Application Reference Number:		2026/0402	
Application Type:		Householder	
Proposal Description:		Conversion of existing attached garage to ensuite bedroom and first floor side extension above	
Location:		27 Chapel Street, Birdwell, Barnsley, S70 5UW	
Applicant:		Mrs Brenda Bentley	
Third-party representations:	Two	Parish:	None
		Ward:	Rockingham

This planning application seeks householder planning permission for the conversion of the existing attached garage to an ensuite bedroom and the erection of a first-floor side extension above it.

Site plan

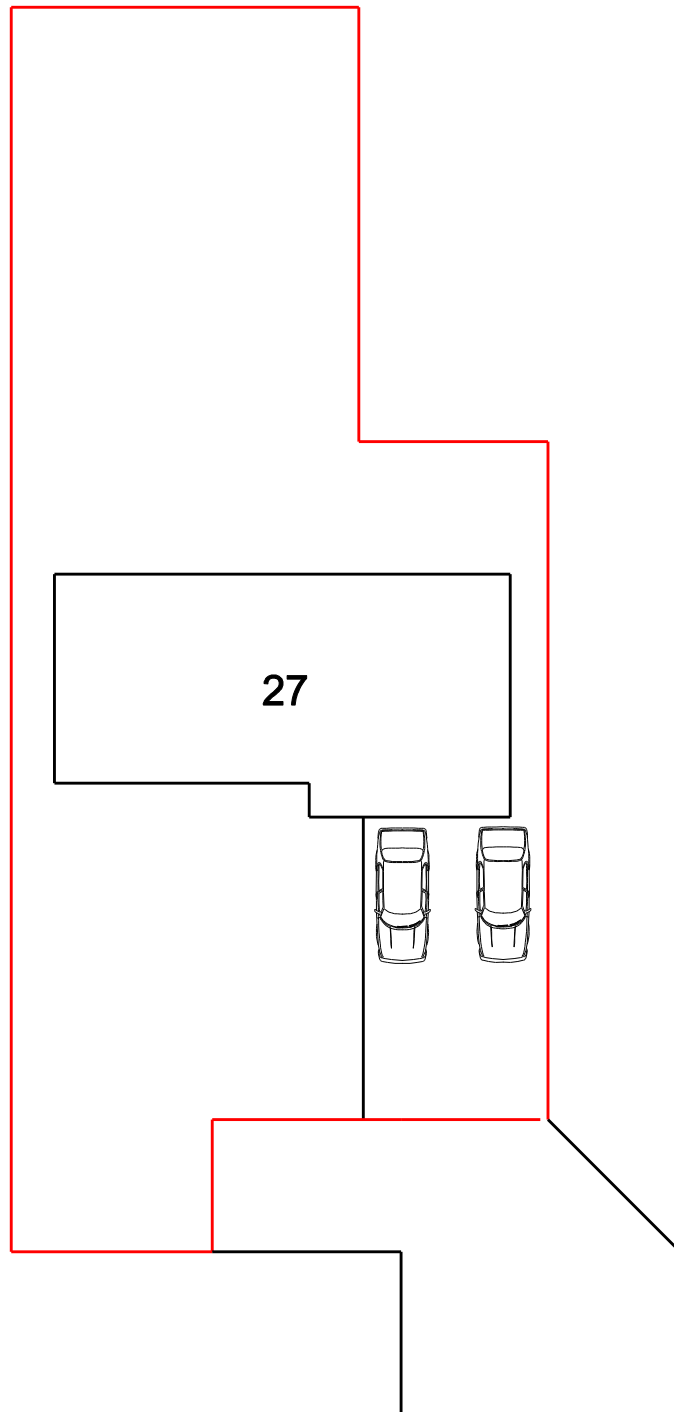
With reference to the amended Site Plan Rev. 2, the proposals now include an extended turning area which will allow vehicles parked on either side of the widened driveway to carry out a turning manoeuvre. A bin store is to be provided at the end of the extended turning area. Highways DC were consulted and raised no objections. It is therefore considered that the proposals will not adversely impact upon the highway and are acceptable from a highway's perspective. This weighs significantly in favour of the proposal.

Proposed Front Elevation

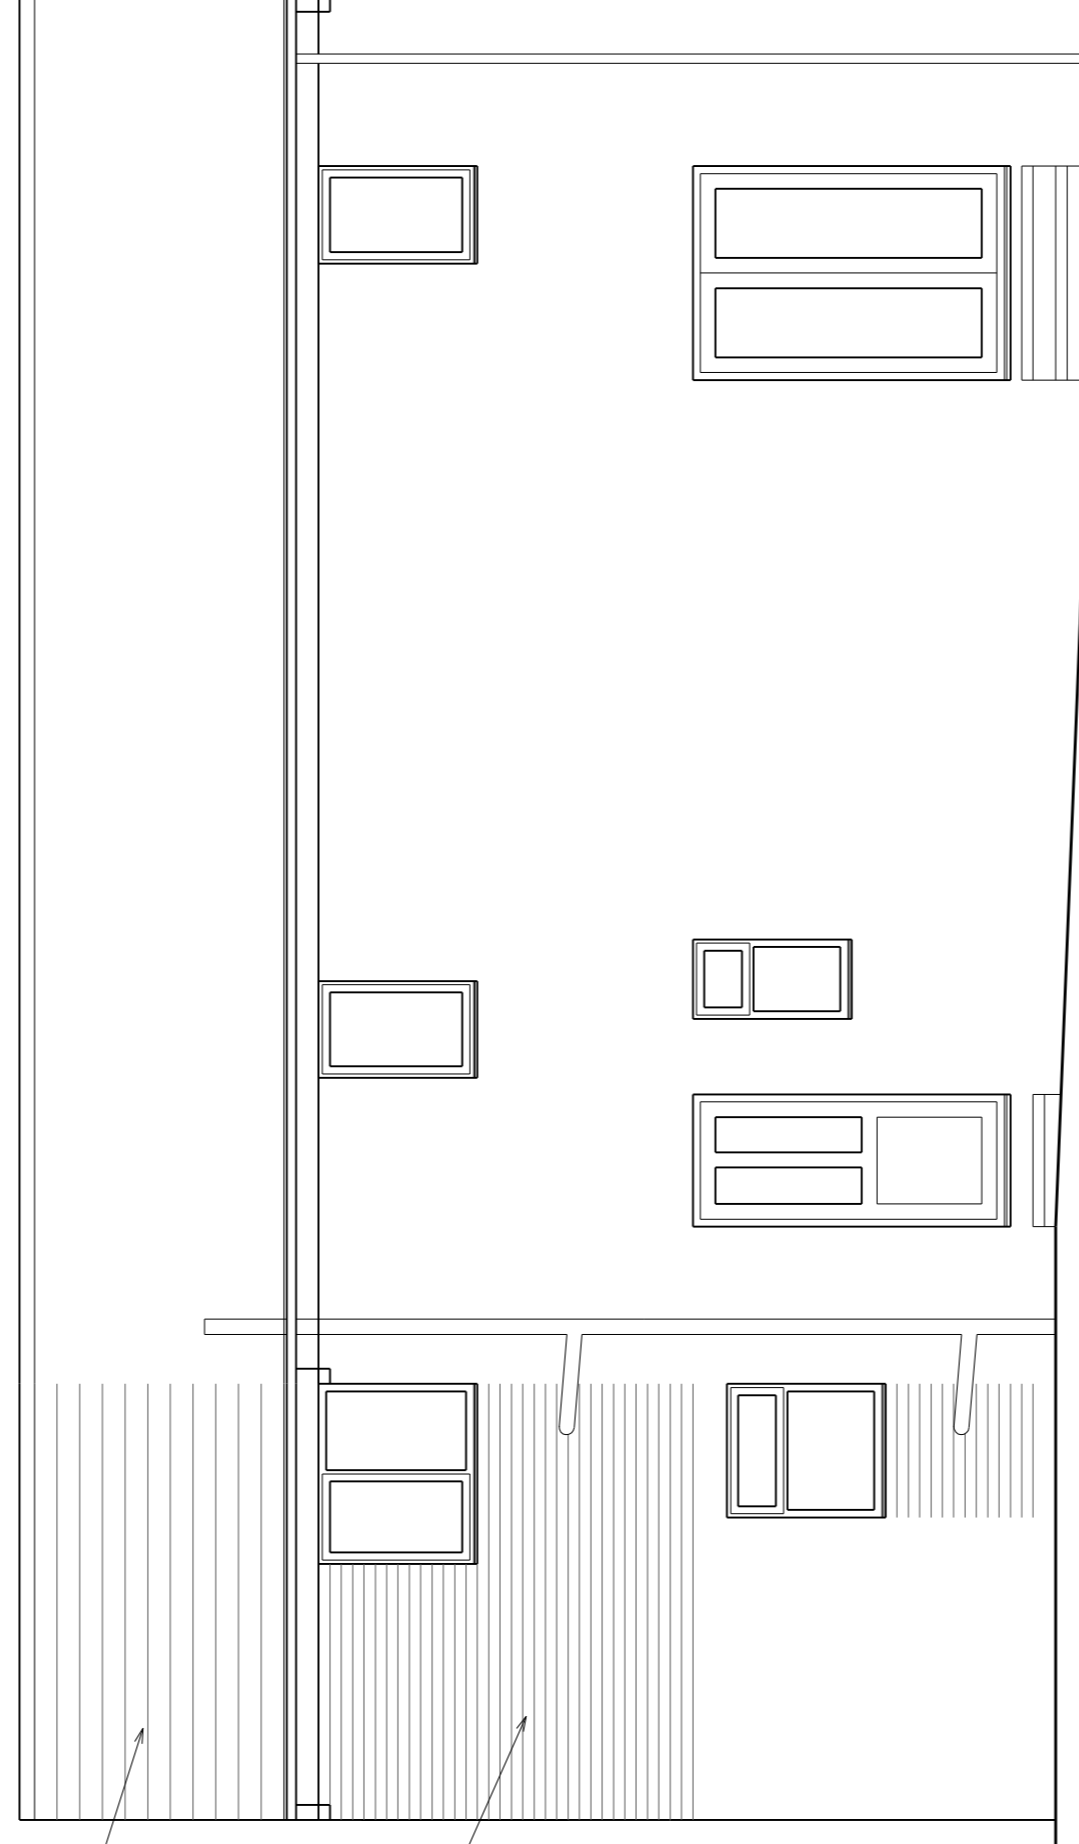
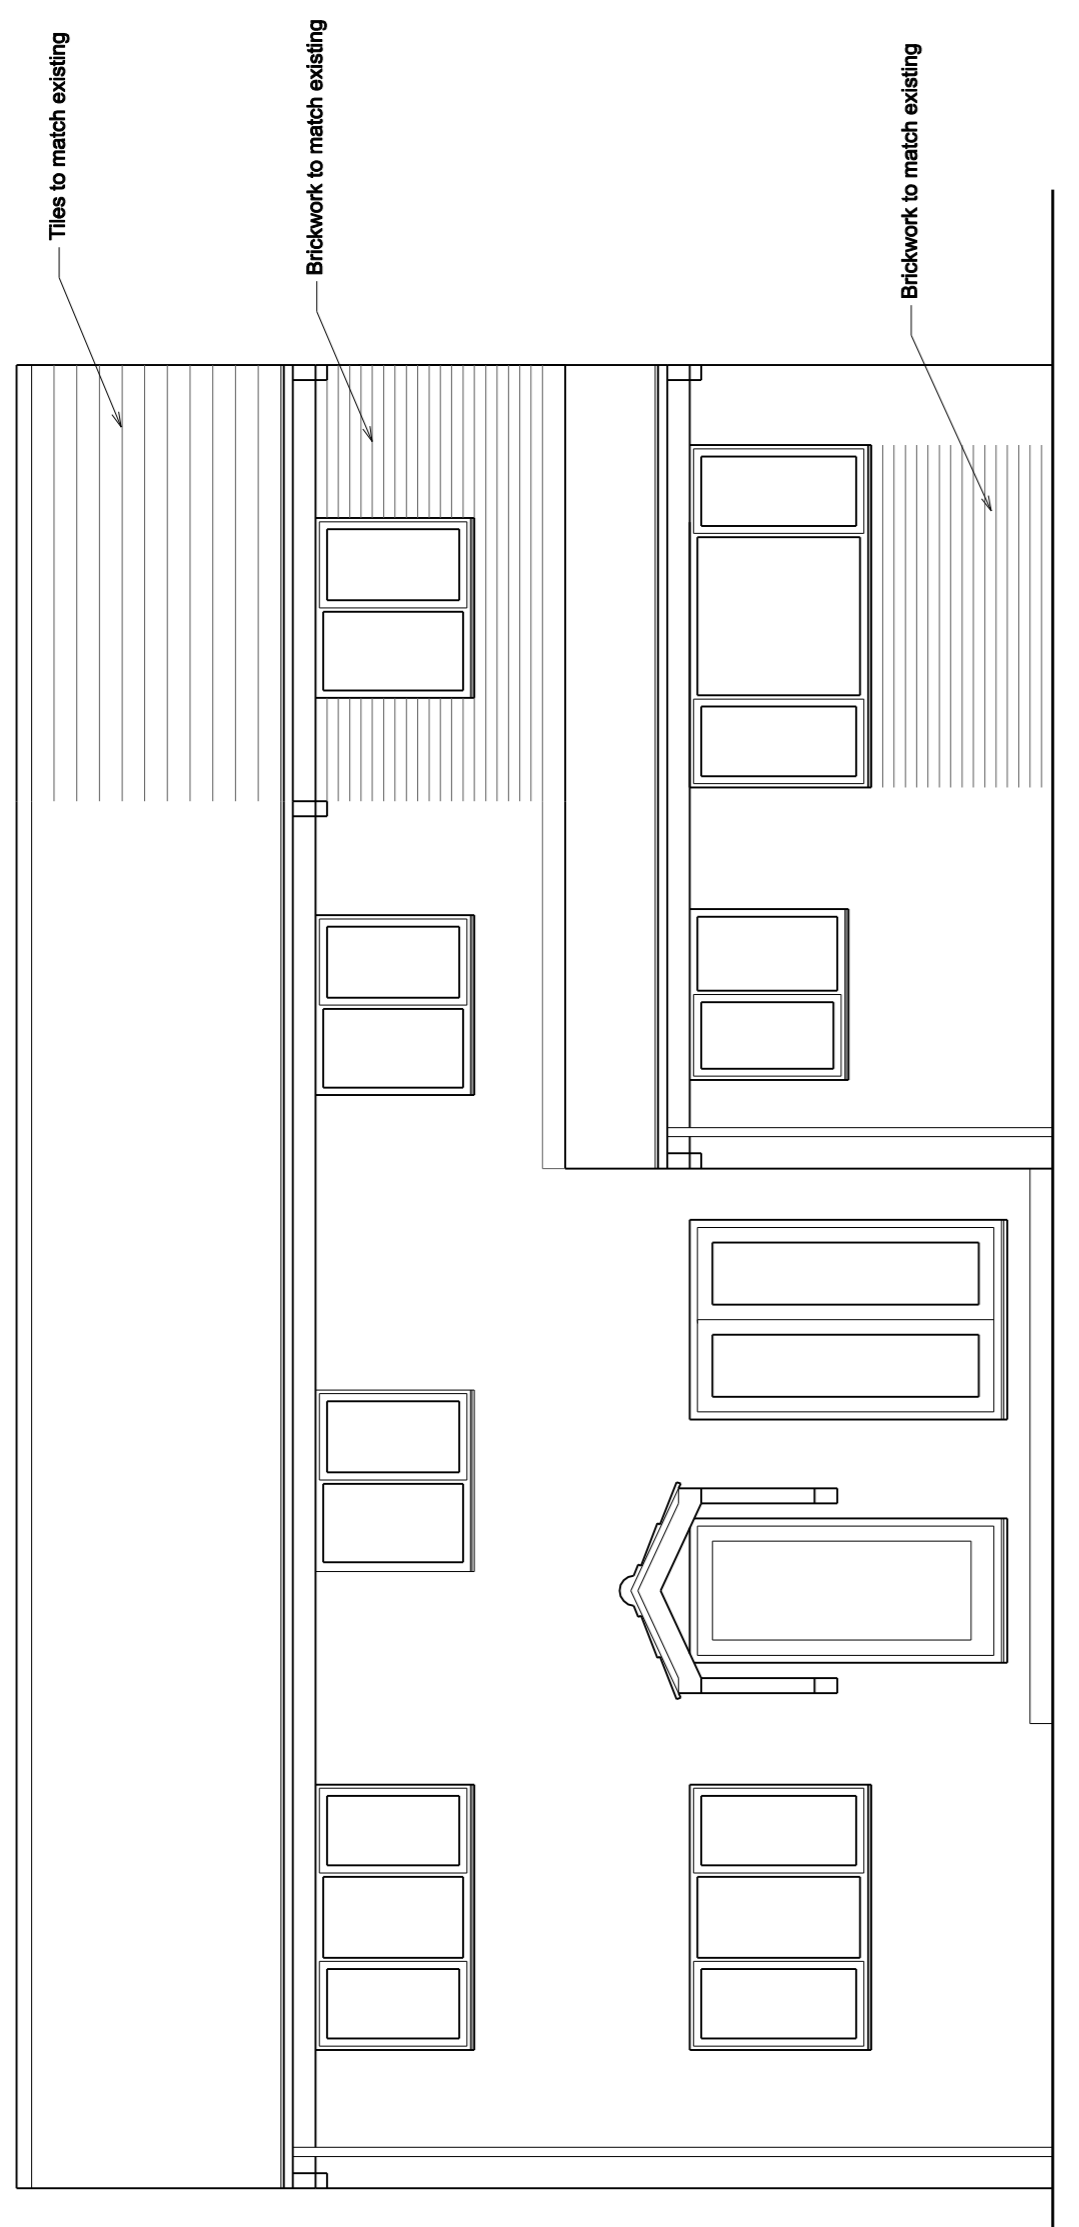
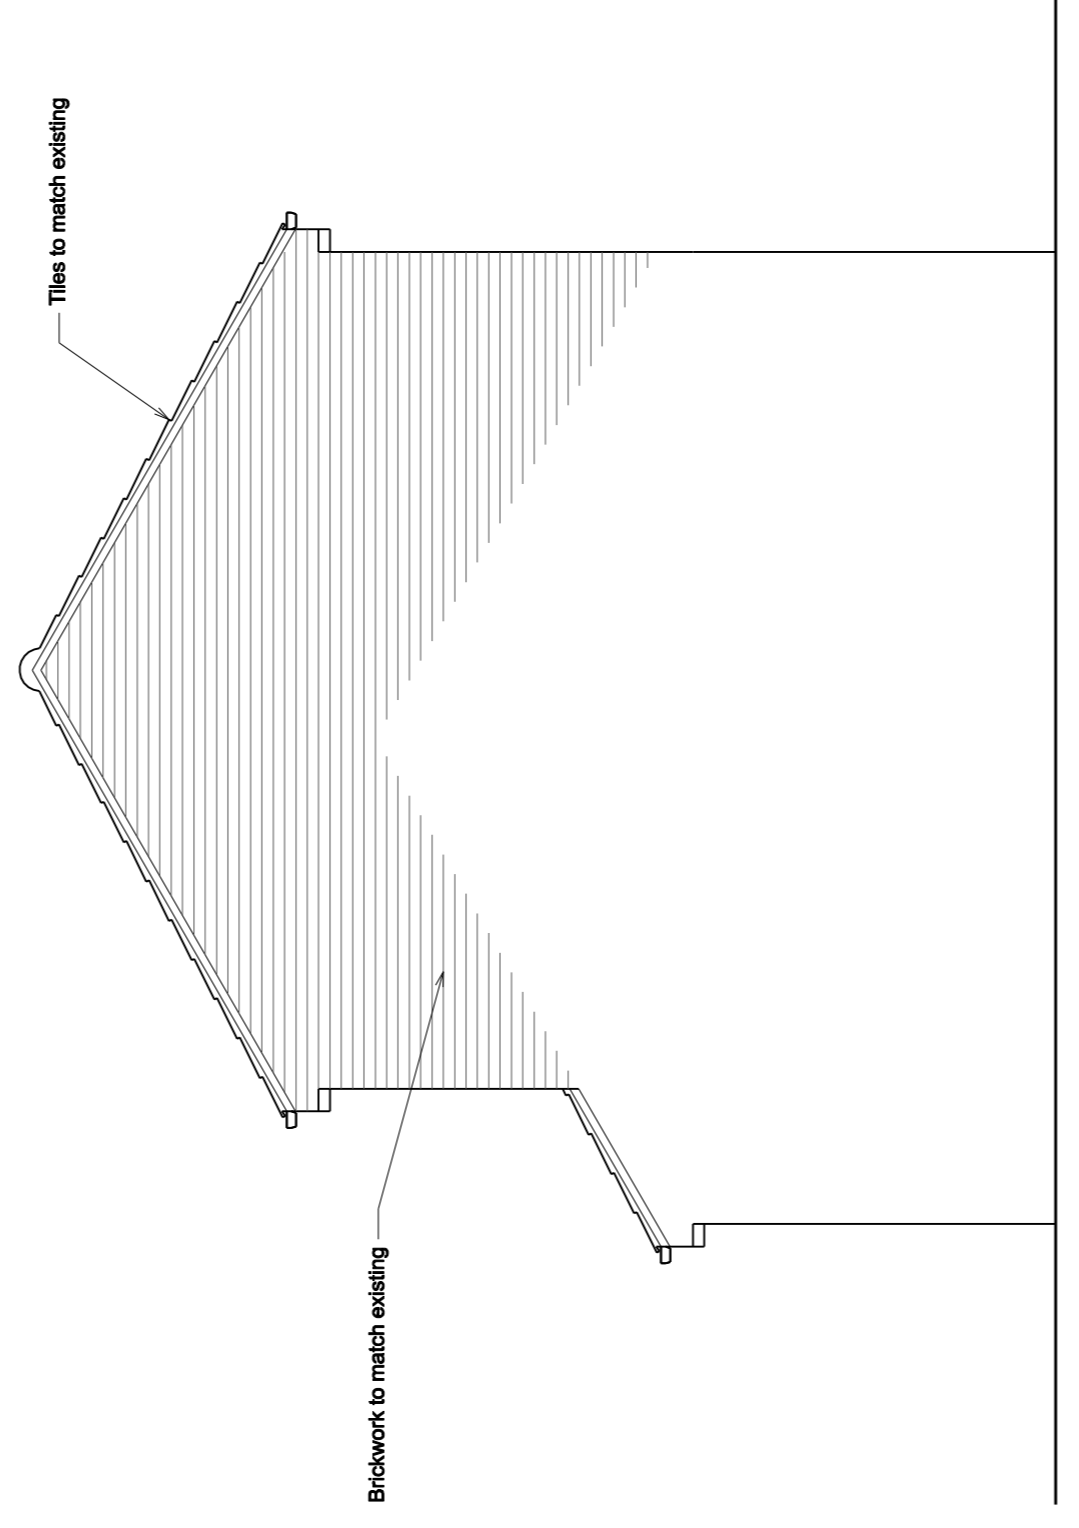
The SPD states *'all two-storey side extensions should therefore have a pitched roof following the form of the existing roof'*. The proposed extension utilises a pitched roof which follows the form of the existing dwelling's pitched roof. The proposed roof is also set down from the main roof line and aligned at the eaves. As mentioned above this ensures that the extension will be seen against the outline of the host dwelling and that the proposed height will be lower than that of the existing dwelling. This weighs significantly in favour of the proposal.

The SPD states *'to prevent a terracing effect and to avoid detrimental changes to the character of the street scene, it will be desirable to provide a setback of at least 500mm from the main front wall of the dwelling'*. The first-floor extension is setback 0.5 metres from the front wall of the existing dwelling at first floor level which is an acceptable setback distance, and this will ensure that the extension appears subordinate. This weighs significantly in favour of the proposal.
